ROYAL RANDWICK RACECOURSE SSD-10285 WINX STAND

Response to Submissions

Prepared for
AUSTRALIAN TURF CLUB
9 April 2020

Figure 3 Amended Landscape Plan with DDA ramp, Ground Floor Masterplan Drawing: DA-1918-02-E

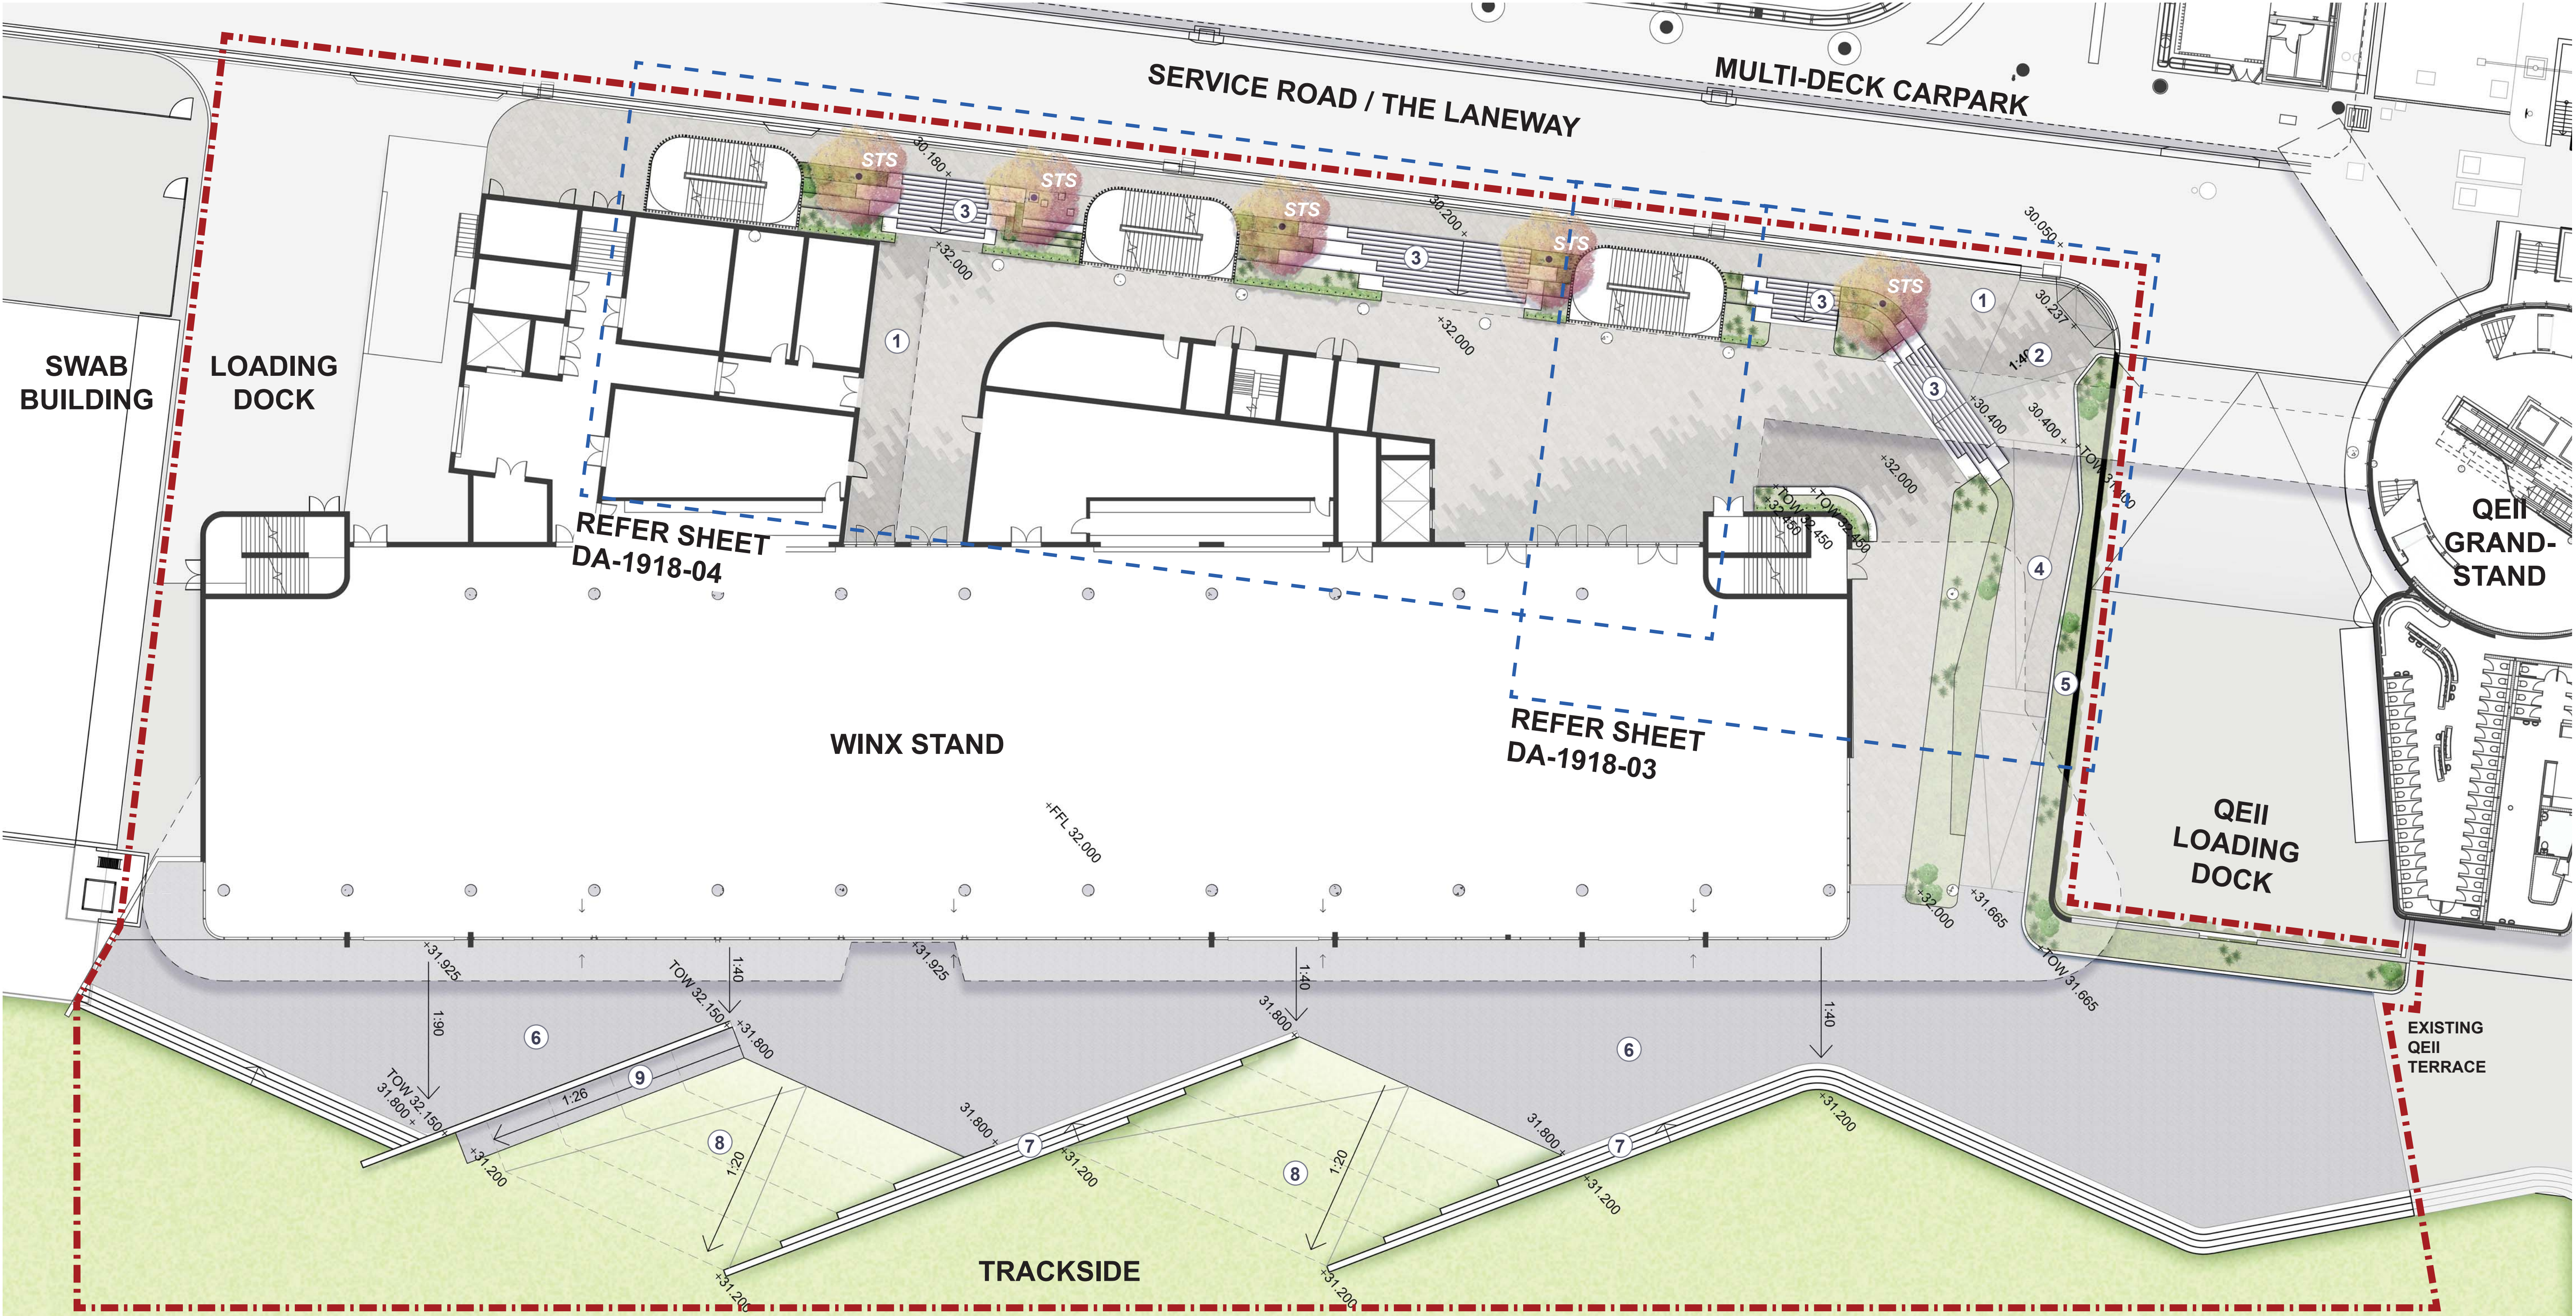
- A new DDA compliant ramp has been added to provide access between the Winx Stand and the trackside lawn area (refer to Figure 3).
- The indicative planting schedule has been amended with alternative vegetation species in response to submissions (refer to Figure 4).

DRAWING No. DA-1918-05 ISSUE E DRAWN jw/wl DATE 22.01.2020

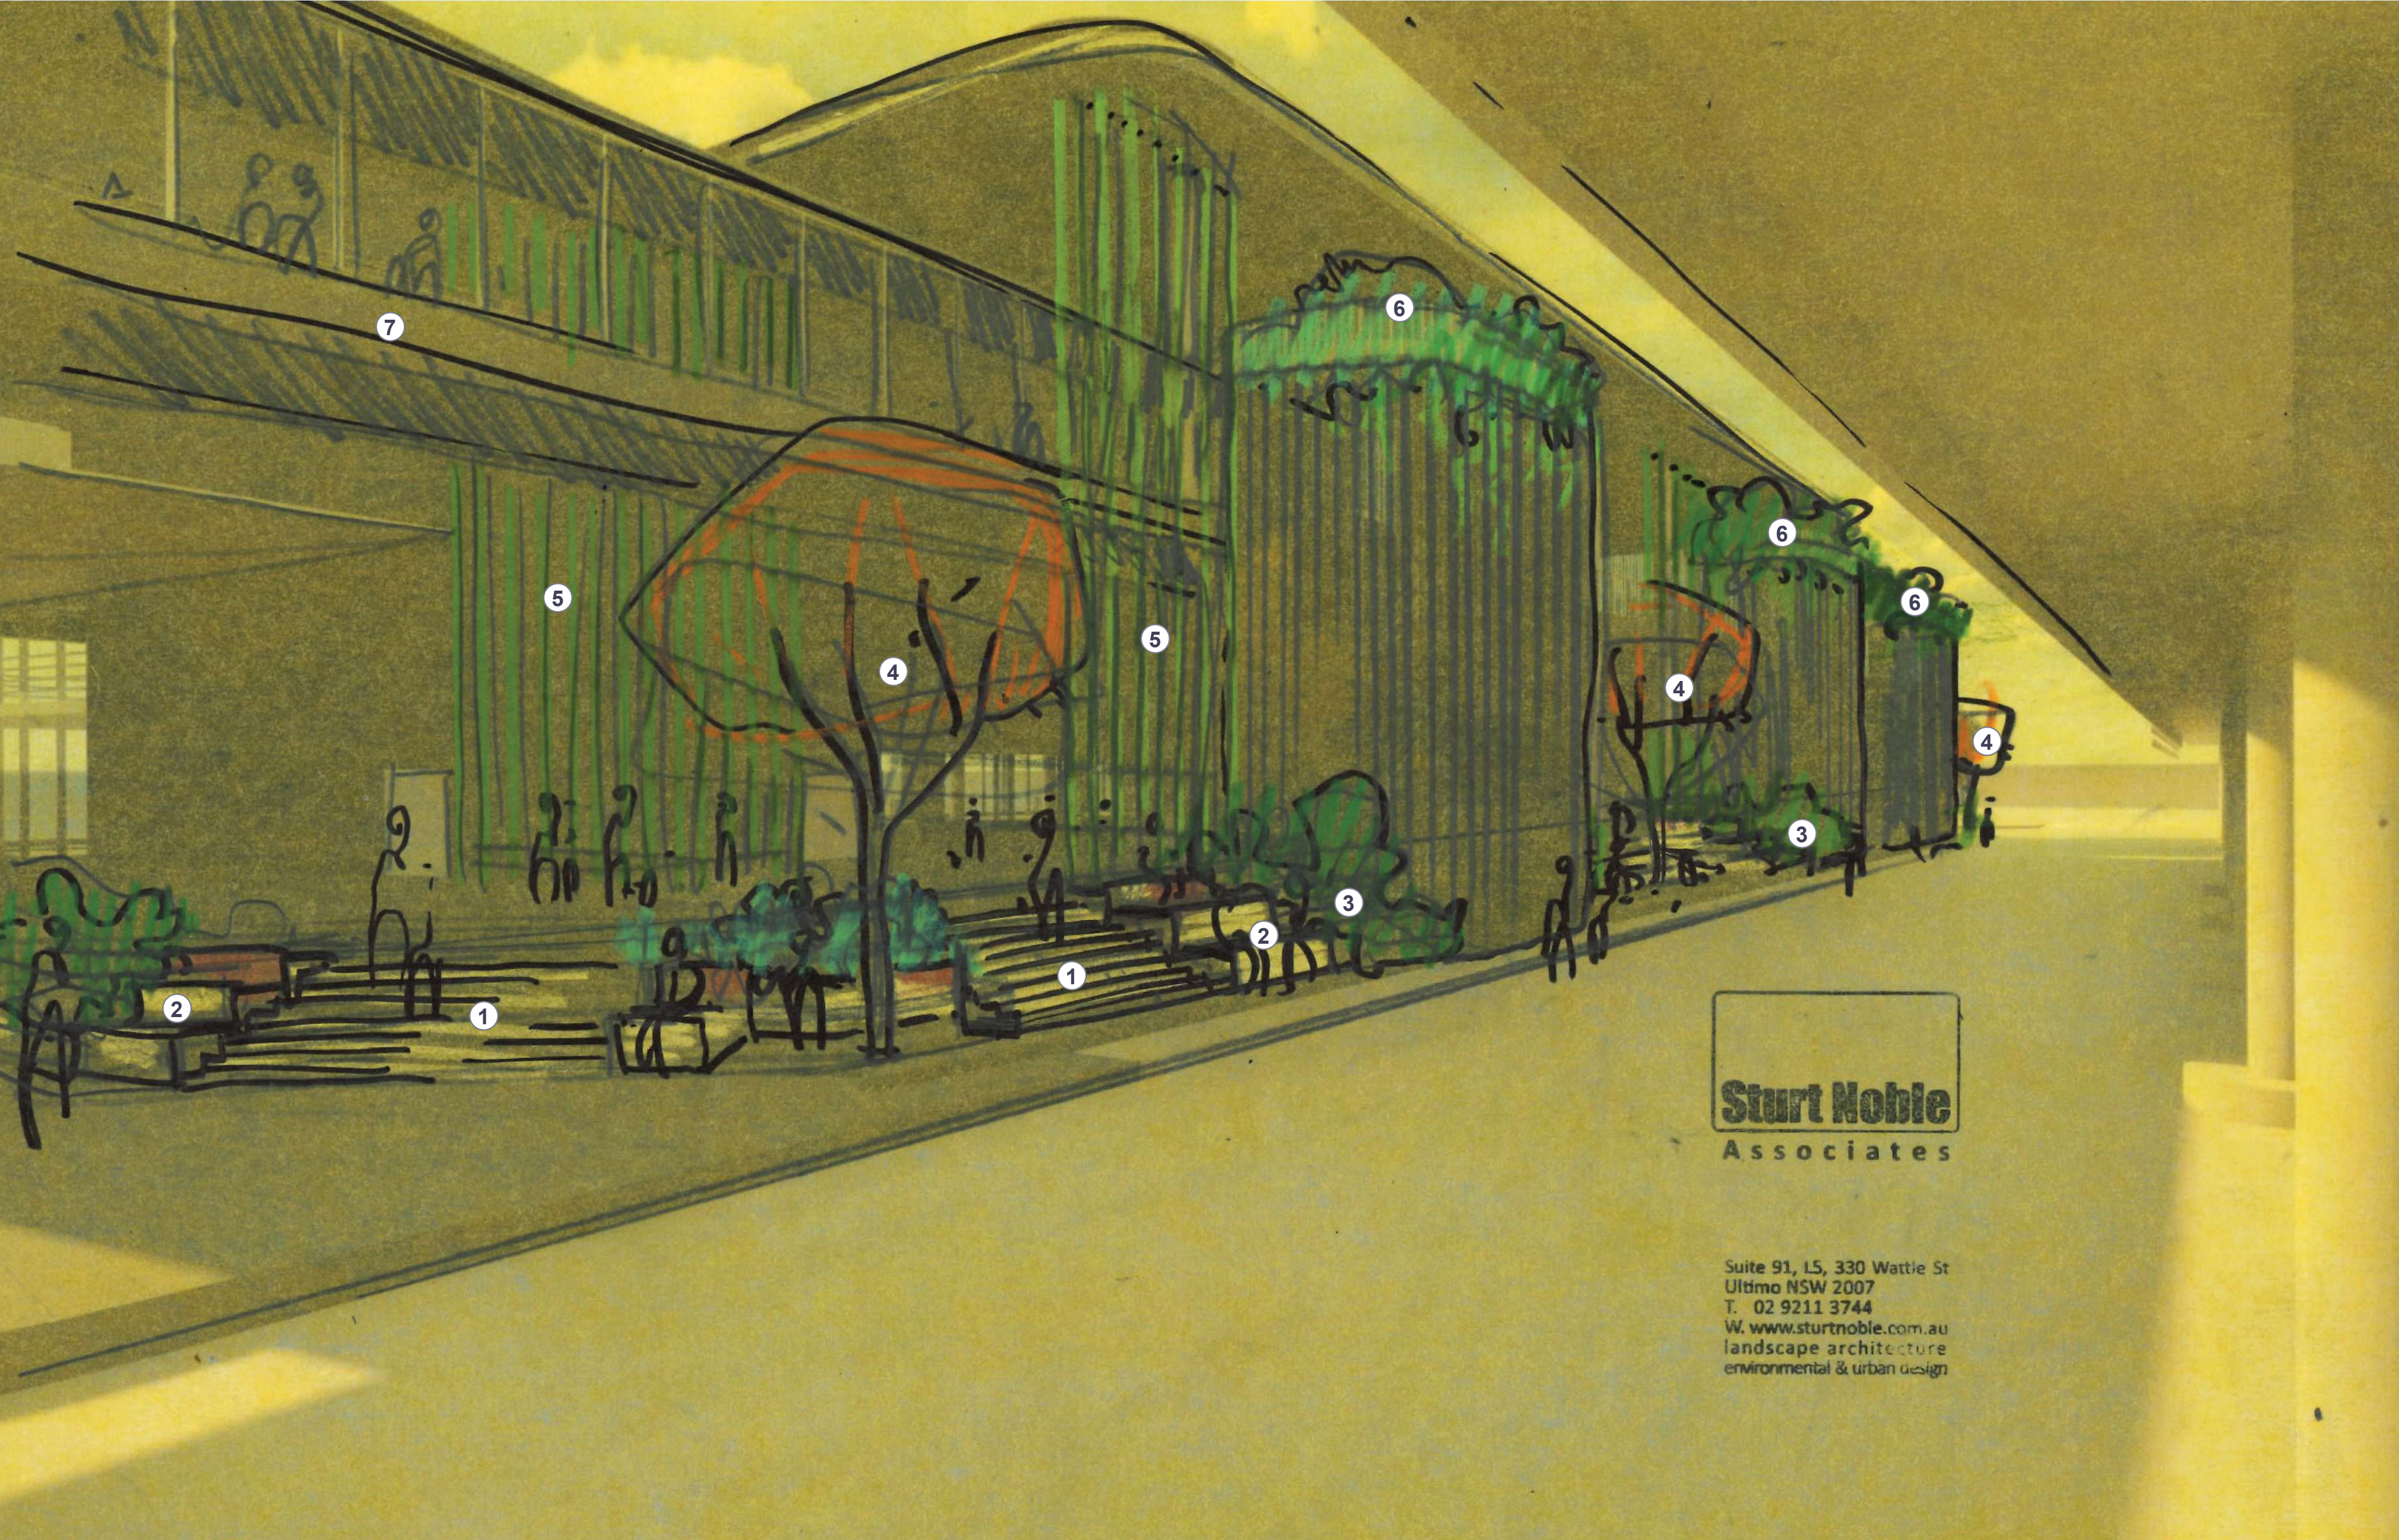
- Revised Level 1 design to spread out the built form massing along the length of the structure to create two separate halls, being Hall 2 – 684sqm and Hall 3 – 660sqm (total of 1,384sqm). This results in a very minor increase of 78sqm to the net total GFA for the hall on Level 1 (original design of the hall on Level 1 was 1,306sqm).
- The previous Level 1 outdoor terrace has been redistributed to a central outdoor terrace between Hall 2 and Hall 3, and two smaller terraces at each end of the structure.
- Revised roof design in response to the revised built form massing.
- Incorporation of solar panels to the roof design to enhance the scheme's environmentally sustainable design and minimise energy consumption.

Cox Architects has amended Level 1 and roof design of the proposal to improve the functionality of the facility when compared to the original SSDA. Figure 5 illustrates how redistributing the massing of Level 1 along the length of the structure results in a more balanced built form and creates a new central terrace space on Level 1. This enables the terrace space to serve both halls and provides further operational flexibility in comparison to the original design. The revised roof design provides partial cover over the terrace spaces to provide greater weather protection to patrons and will provide more operational flexibility for the Winx Stand during events. This includes providing a more permanent weather protection solution in lieu of requiring temporary solutions (i.e temporary marquees) implemented for large scale events.
